Recommendation Report for Planning Permission

REF NO: BE/112/19/PL

LOCATION: Land adjacent to
12 Plover Close
Bognor Regis
PO21 4LZ

PROPOSAL: 1 No dwelling (resubmission following BE/65/19/PL)

Title:
New Bungalow Next to
12 Plover Close
Bognor Regis
West Sussex PO22 9HD

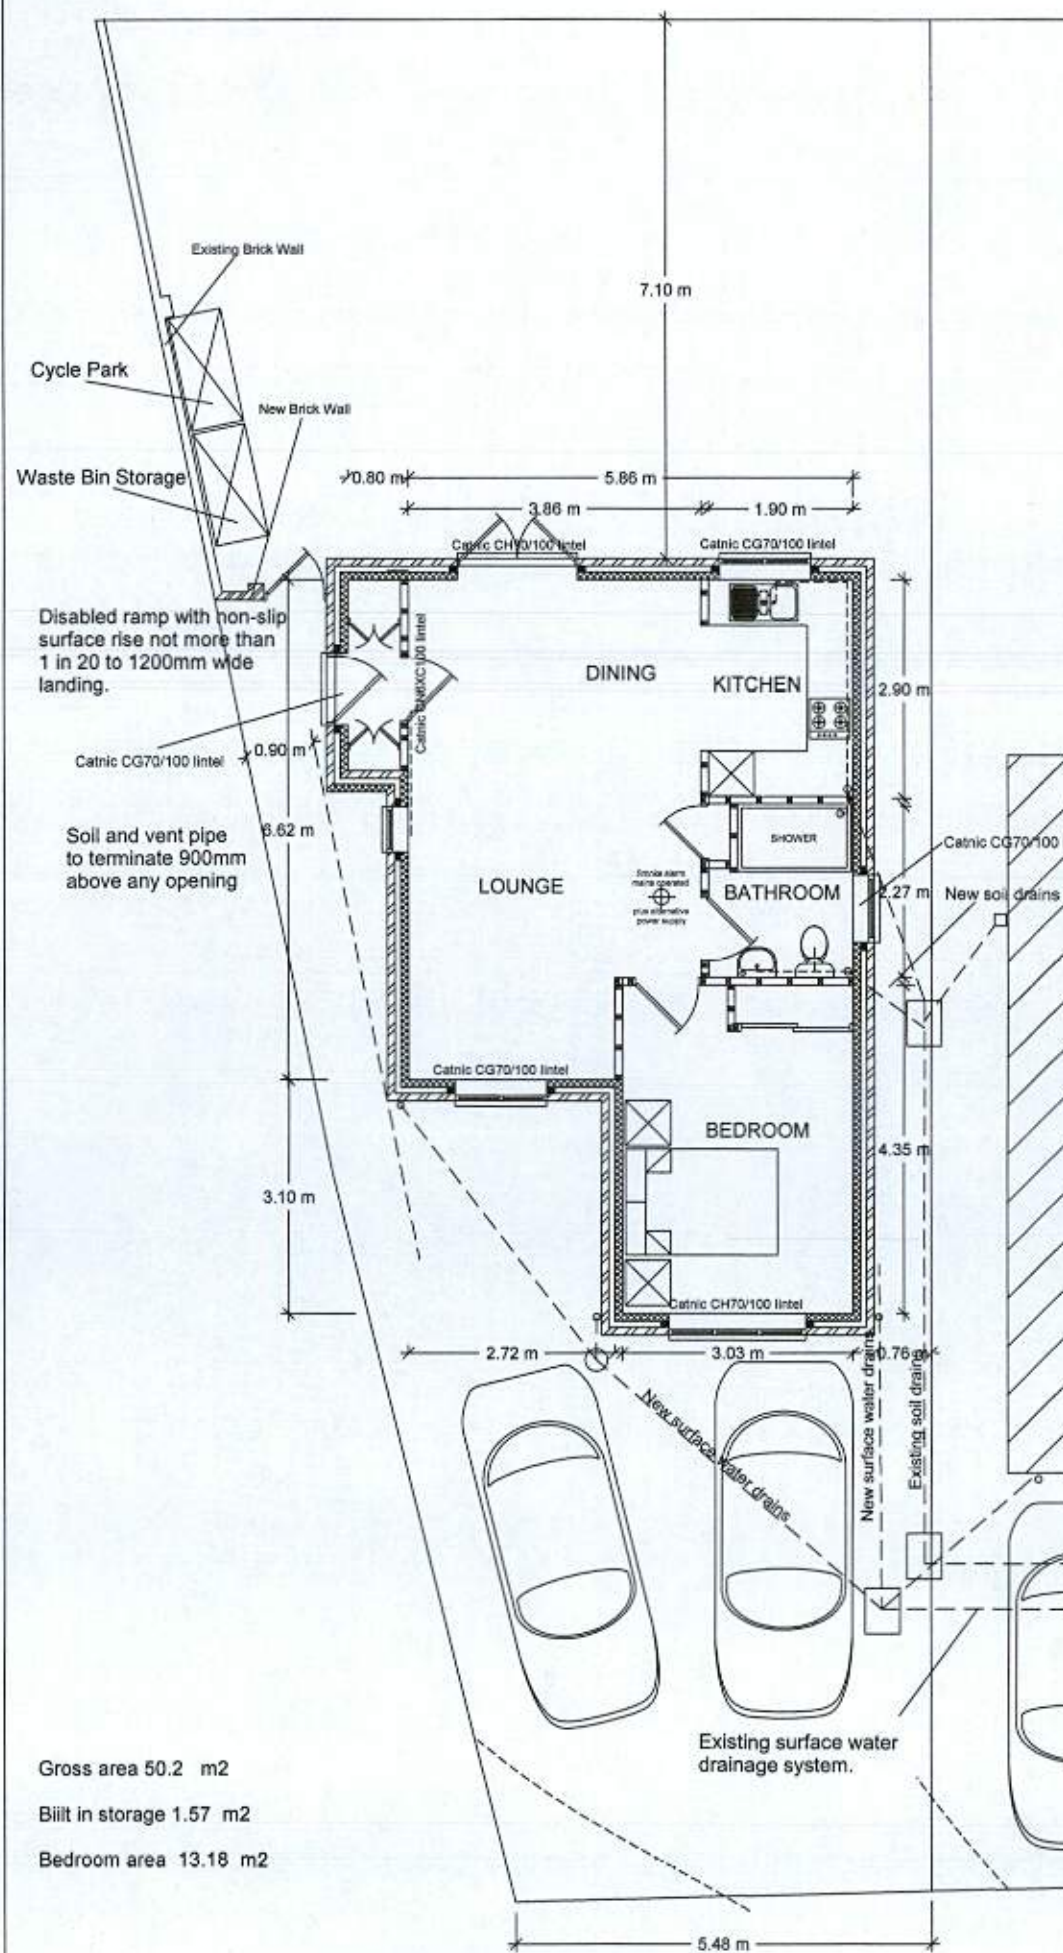
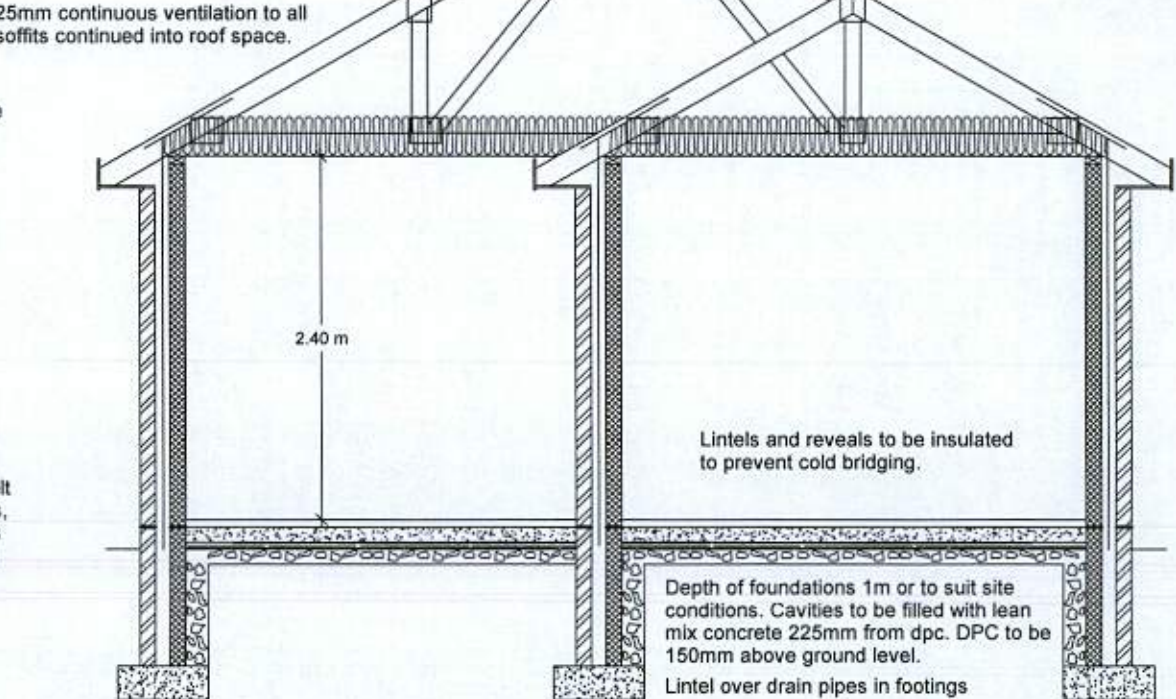
The proposal is for a new single storey dwelling in the grounds of No 12 Plover Close, to the east of this property on a corner plot. It would be located in close vicinity to the existing dwelling at no.12, within a distance of 1.7m from its side elevation, would be set back from the front building line by 2.5m and would not have a proper relationship with the street (the end of cul de sac) appearing cramped in the street scene.

Having regard to the existing character, layout and density of the area, it is considered that the proposal would represent an overdevelopment of this constrained site resulting in a cramped appearance and would not be in keeping with the established density, layout and pattern of development (which consists of a mix of semi-detached and terraced dwellings with substantial gaps in the between) and would fail to integrate with its surroundings harming the character of the street scene. The proposals would therefore conflict with policies D DM1 and D SP1 which requires development of good design, to make efficient use of land, but in the same way respond to the character of the area. Additionally, the proposal would not respond to the locality and would fail to integrate visually as per Bersted Neighbourhood Plan policies ES1, HDQ2 and HDQ5.

The Proposed Ground Floor Plan shows a waste bin storage area which would be approximately 600-700mm in depth and 1.5m in width. A bin storage and the existing brick boundary wall would provide screening from public view. The store would be sited adjacent to the entrance door to the property so would be easily accessible to the occupants. No collection point on or adjacent to the kerbside has been shown on the plans. The average dimensions for a 240l wheelie bin is 730mm deep and 575mm in width. The proposed bin storage would therefore appear to not be deep enough to accommodate 2 x 240l wheelie bins required for refuse and recycling. However, it may accommodate smaller types of bins. Notwithstanding this, details of bin storage could be secured by planning condition to ensure compliance with policy and would not form a reason for refusal.

The plans indicate cycle parking storage, which would be deep enough to accommodate at least one bicycle, however it appears it would not be wide enough. The WSCC parking standards and Arun Parking SPD require 1 cycle parking space for a 1 bedroom property. However, it may accommodate smaller types of bikes e.g. fold up etc. Notwithstanding this, details of cycle storage could be secured by planning condition to ensure compliance with policy and would not form a reason for refusal.

The plans indicate the installation of new surface water drains on the site. However, other opportunities such as permeable hardstanding for the driveway and the installation of a water butt and green soakaway could have been suggested. Notwithstanding this, details of SUDs could be secured by planning condition and since some SUDs are shown this would not form a reason for refusal.

1 The site, by virtue of its constrained size and shape, is considered unsuitable to accommodate

a dwelling that meets the internal space standards and provides adequate garden space without damaging the character of this established residential area. The proposal would represent overdevelopment of the site resulting in an unduly cramped form of development, would not be in keeping with the established pattern of development and density of the area and would fail to integrate visually with its surroundings harming the character of the street scene. The proposals would thereby conflict with policies D DM1 and D SP1 of the Arun Local Plan, and policies ES1, HDQ2 and HDQ5 of the Bersted Neighbourhood Plan.
